West Nowra Resource Recovery Park – SSD 15_7015

I refer to the Department of Planning and Environment's (DPE) notification of exhibition of Development Application (DA) SSD7015 and Environmental Impact Statement (EIS) for the proposed West Nowra Resource Recovery Park (the Proposal) located at 114 Flatrock Road, Mundamia being Lot 342 DP 257515 (the Premises) and DPE's invitation for the Environment Protection Authority (EPA) to provide comments.

APPENDIX A: EPA Recommended Conditions for Stage 1 of the proposed West Nowra Resource Recovery Park

APPENDIX B: EPA comments for Stage 2 of the proposed West Nowra Resource Recovery Park

Predicted peak odour impact (99th Percentile, P/M60)
Current landfill

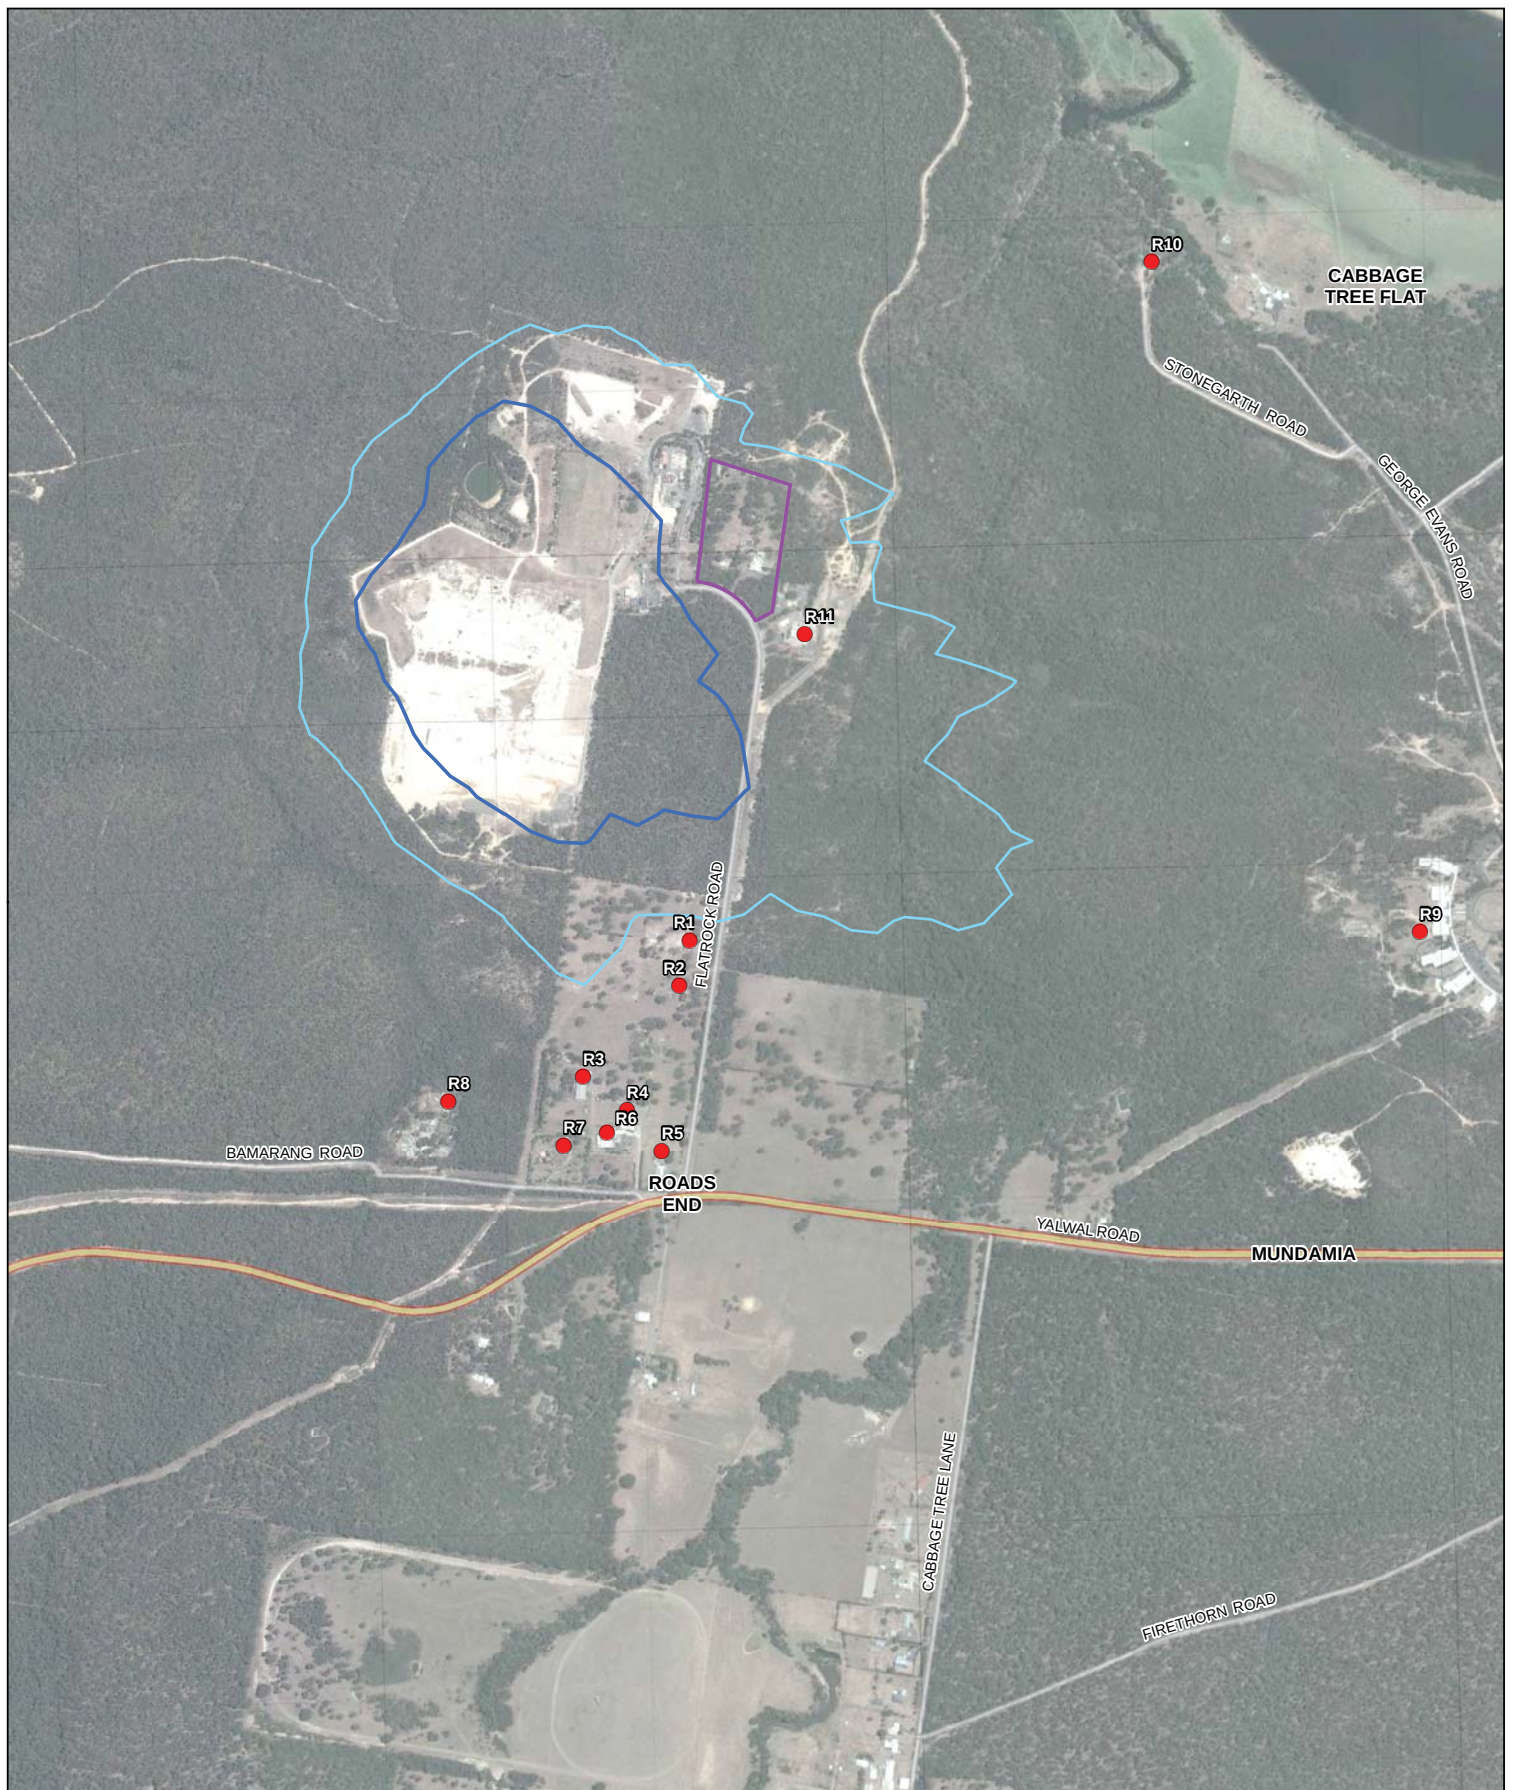
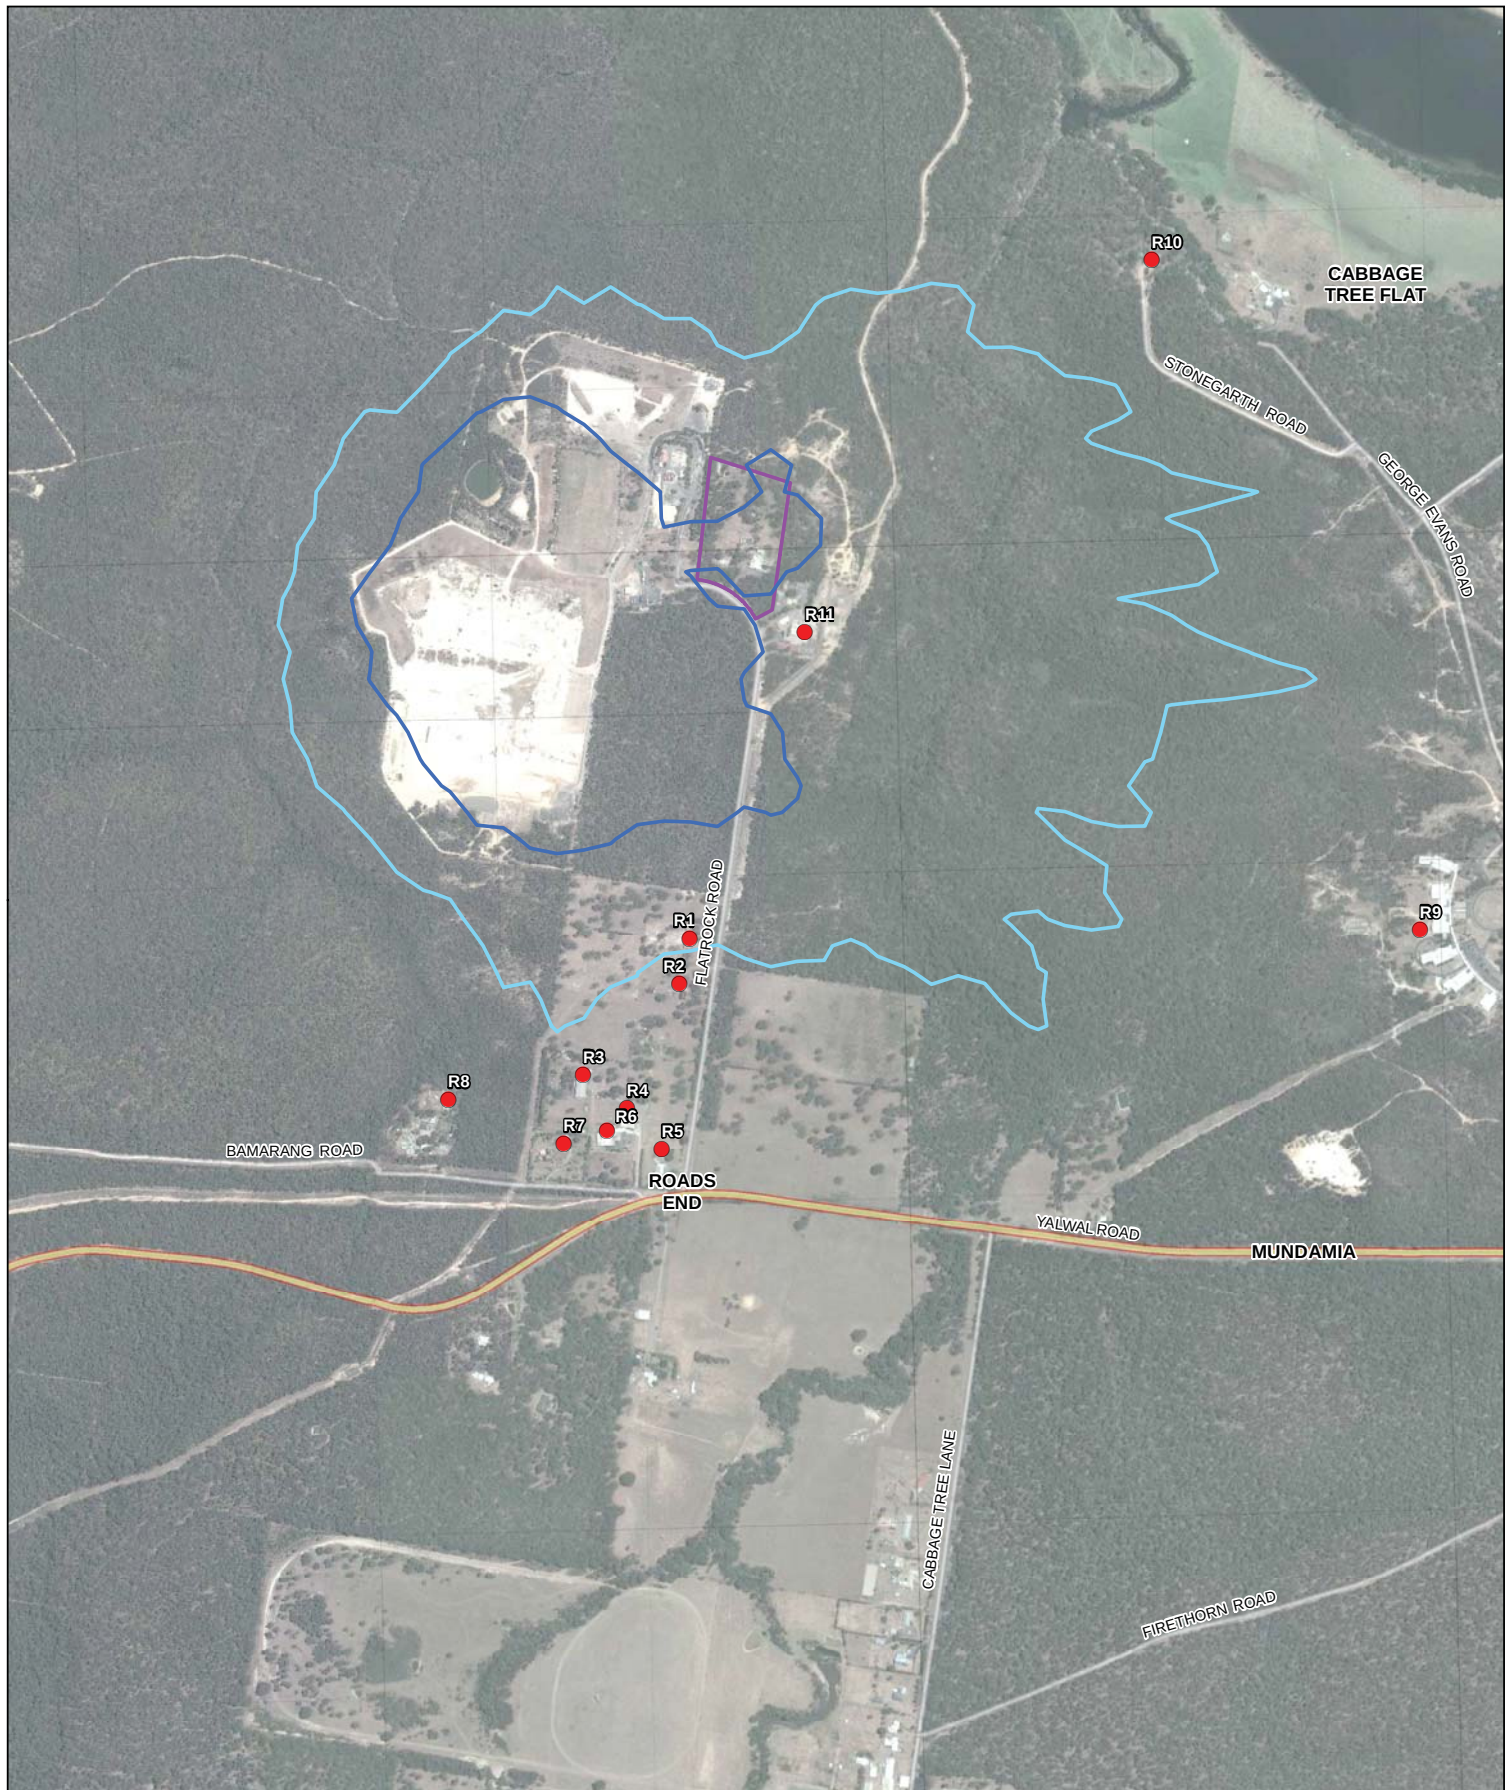
2.1. Analysis of impacts for at least one full representative year, the choice of year being justified from within at least five years of meteorological data. The choice of time period provided with the concept outline was not discussed and justified.

2.3. Choosing an odour criterion based on the total affected population – resident and working.

- 2.5. Options for reducing odour should be noted as part of the approach to responding to odour complaints.
- 2.6. Care to present observational data consistent with its descriptive analysis.
- 2.7. Care to provide assessment results clearly and related directly to air quality criteria chosen for the project.
3. The proponent must be able to demonstrate that there is negligible impact from odours due to the maturation process being conducted not in an enclosed building

Figure 14.3 Expected site water balance volumes

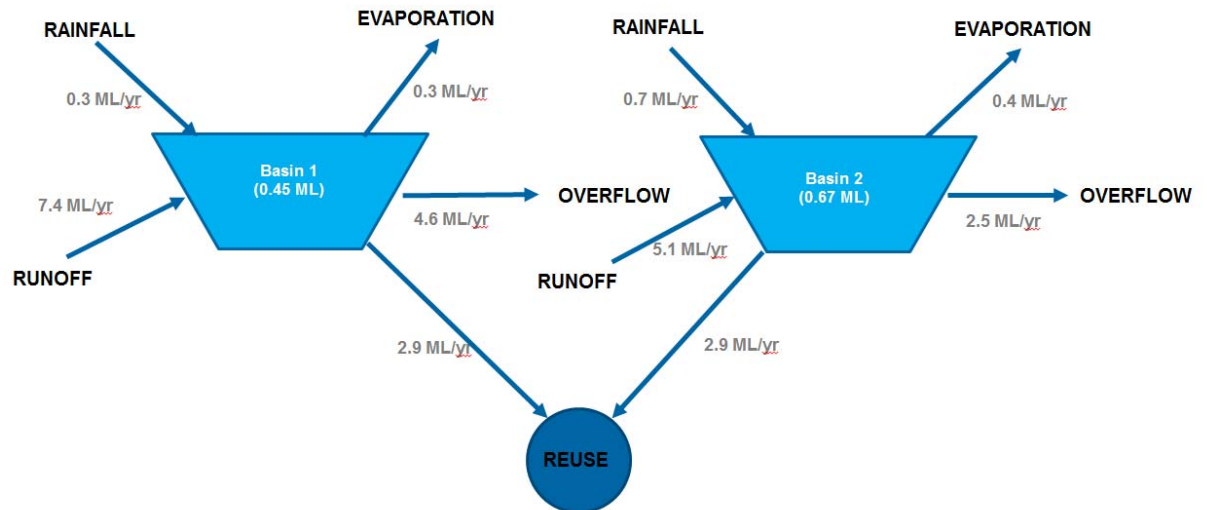
1. Consider the use of rainwater tanks or other type of enclosed system to capture clean runoff from roof surfaces to minimise the potential for overflow events from sediment basins.
2. If sediment basins are used for the Proposal provide the location of proposed overflow points for the basins and the expected flow path and receiving water body in the event of an overflow from the basin.
